Consultation Response from: KC Environmental Health (Pollution & Noise Control)
2025/93343 - Unit 13 and 14, Shaw Park, Silver Street, Moldgreen, HD5 9AF
Use of units 13 and 14 as brand-approved accident repair centre and installation of two industry standard spray booths within the existing building
Date Responded:
Tuesday, 30 June 2026

Responding Ref:
WK/202613335

Figure 6: 2D Grid Noise Map of daytime Initial Impact Assessment

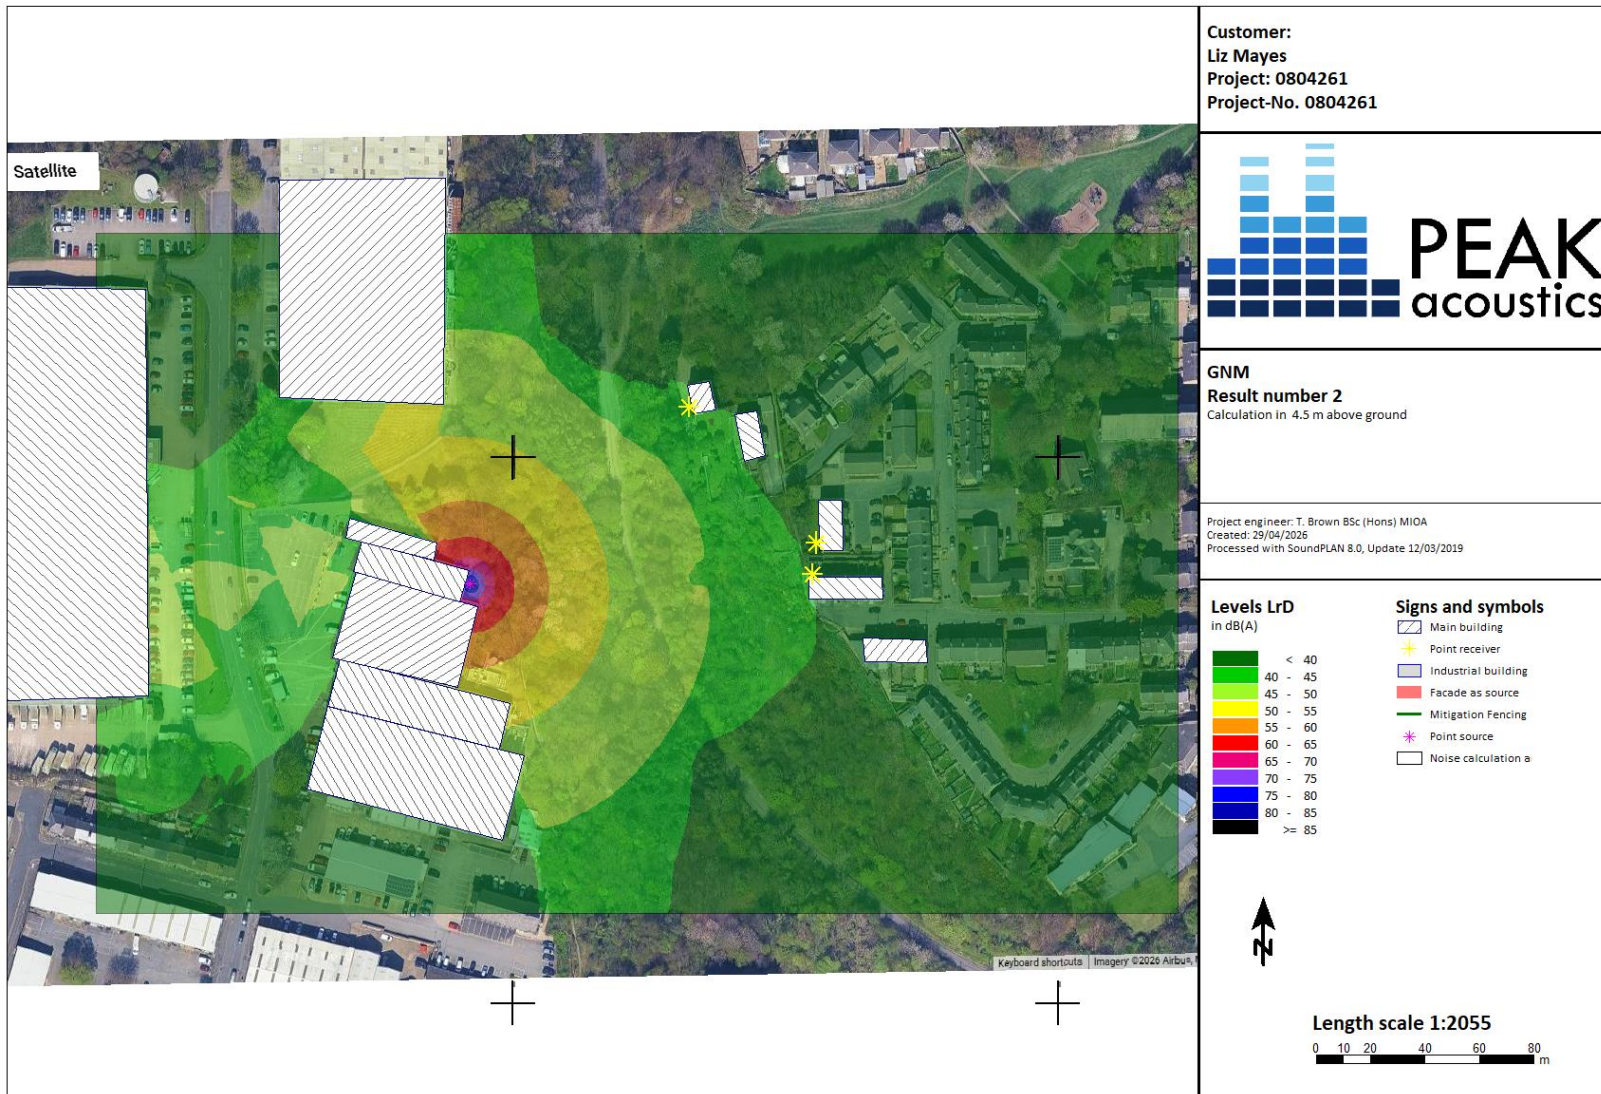
The report presents the findings of a 24hr environmental noise survey undertaken on the 14th-15th April 2026. The baseline environmental noise survey measurement position (MP1) *"was positioned to the northeast site boundary at a height of approximately 2 metres"*. This was *"deemed representative of sound levels at 'NSR 1' during the typical operational periods of the development"*. However, the nearest noise sensitive receptor is 100m away from the Shaw Park industrial estate, and therefore, any noise levels measured at MP1 on site

will benefit from 100m of distance attenuation, reducing operational noise levels between those on site and those experienced at the nearest noise sensitive receptor NSR1. Therefore the use of an on-site measurement position *"as representative"* is likely to result in an over-estimation of the environmental noise levels at NSR1. MP1 will be measuring operational noise levels from the Shaw Park industrial units. This is demonstrated in Figure 4: Measured Background Sound Levels Time History where it is clear that operational on-site noise levels formed part of the measured noise levels, and are therefore not representative (without 100m distance attenuation):

NSR1 is 100m away from these noise sources and therefore a measurement position on site cannot be “deemed representative of sound levels at ‘NSR 1’ for use within calculations without distance attenuating these measured operational noise levels. Environmental Health do not consider it appropriate to use measured on site noise levels as representative of noise levels at NSR1 – NSR1 is located 100m away in a residential setting separated by vegetation.

The BS4142:2014 uses the ISO-9613-2 - Attenuation of sound during propagation outdoors distance attenuation calculation to reduce the on-site noise levels using ‘SoundPLAN’ to calculate the noise output from the extract flues sound power levels – resulting in a source noise level of 84 dB LAeq,T at 1 m from the source reducing the source noise level to 42dB LAeq,T at NSR1. Using this scenario, the specific sound will benefit from distance attenuation noise reductions, whereas the other measured operational noise sources measured “to the northeast site boundary at a height of approximately 2 metres” will not, and form part of the representative sound levels at NSR 1.

We do not consider the submitted noise assessment using this flawed methodology to be acceptable. Baseline noise levels will require revising and the BS4142 assessment repeating with the corrected NSR background sound level – either by:

‘Further to the Environmental Health comments on the Noise Impact Assessment for Units 13 and 14, Shaw Park, we have undertaken additional background sound monitoring at Mount Zion Road, in the vicinity of the nearest residential receptor.

The representative background sound level measured at this location for the 08:00–17:00 operational period was 51 dB LA90,T.

The original assessment adopted a daytime operational background sound level of 52 dB LA90,T. Repeating the BS 4142 comparison using the directly measured receptor-area background sound level gives the following outcome:

Specific sound level at NSR1: 42 dB LAs

BS 4142 character correction: +3 dB

Resulting rating level: 45 dB LAr

Representative background sound level: 51 dB LA90,T

Difference: -6 dB

The revised comparison therefore remains below the representative background sound level and is still indicative of a low impact in accordance with BS 4142:2014+A1:2019.
